**From:** [Laura Van putten](#)  
**To:** [Anthony Kong](#)  
**Cc:** [REDACTED]  
**Subject:** FW: SSD-9522 MOD4 - Frasers/Altis 657-769 Mamre Road Kemps Creek  
**Date:** Wednesday, 3 November 2021 5:09:00 PM  
**Attachments:** [image002.png](#)  
[image003.png](#)  
[image004.png](#)  
[image005.png](#)  
[image006.png](#)  
[P0036332\\_Aerial\\_0921.jpg](#)  
[IF2-KC-FS-550-B.PDF](#)  
[CO13362.01-SK30-A.PDF](#)

SLR layout (CO13362.01-SK30-A):

#### Proposed interim design – IF2-KC-FS-550-B

Figure 16: Potential Intersection Layout (Signalised Intersection) for SLR / Bakers Lane (in 2036)

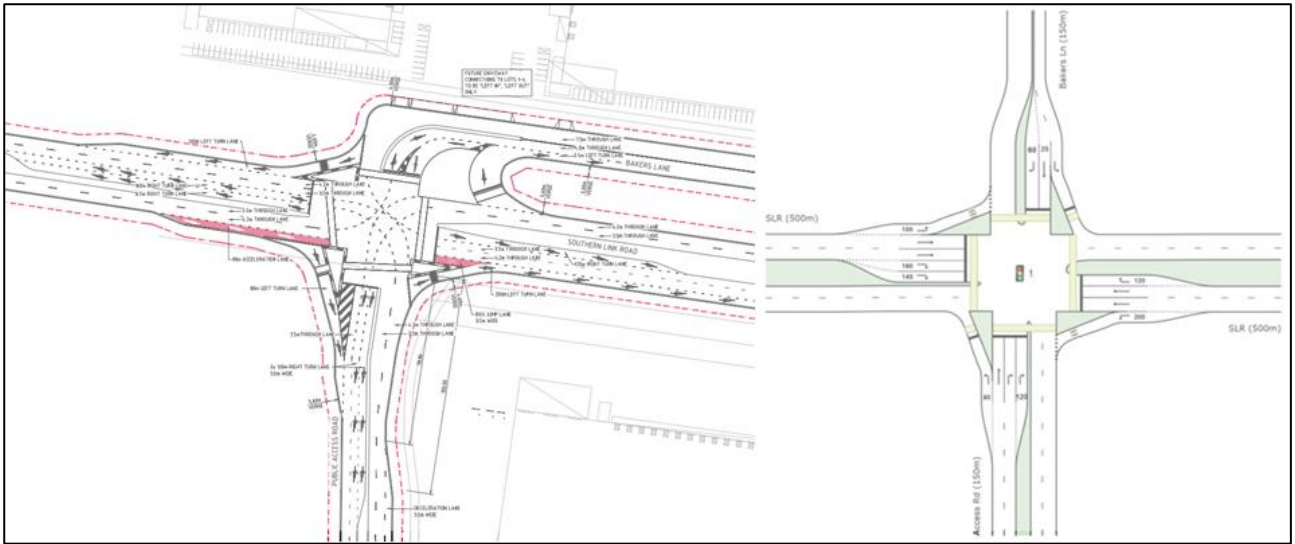
- Signal configuration:
  - TfNSW would require the signals to be designed as double diamond. This allows for better flexibility during time of heavy congestion.

- Swept paths are required for further review. It is difficult to comment on the high angled entry without seeing the swept paths. Questions are raised as to whether a B-double could achieve the angles at the norther leg.

- North leg:
    - The high angle of the north leg reduces visibility to the signals and is considered not acceptable
    - The major movement will dominate the other movements which raises efficiency issues.

- Minimum distance required between turning vehicles is 2 metres – clarify distance
  - It is unclear why a bus jump was not provided for the eastbound lane

- Why is there a chevron section on the south leg. This is not supported.
- Pedestrian safety
  - The west pedestrian leg extends over 7 lanes of traffic. There needs to be consideration of a staged crossing. Alternatively if there is low pedestrian movements, the median is to be wide enough to store a person and to include a push button. This should be provided on the west, and east leg of the intersection. This will require a larger footprint and should be identified now as the current arrangement will not be supported.

- North leg - The angle of the left turn slip lane creates vision impairments to the pedestrian signals and not accepted on safety ground.

- A modelling memo needs to be provided with the signal design to understand what steered the design.

- extending the north leg straight north as opposed to following the current bakers lane alignment. This will remove most of the abovementioned concerns with regards to the obscure angle of north leg.
- Could the north leg left slip be relocated away from the signal as a separate uncontrolled intersection? If this is considered there will need to be adequate distance from the SLR/Mamre Road intersection so as to not have lane changing issues close to signals.
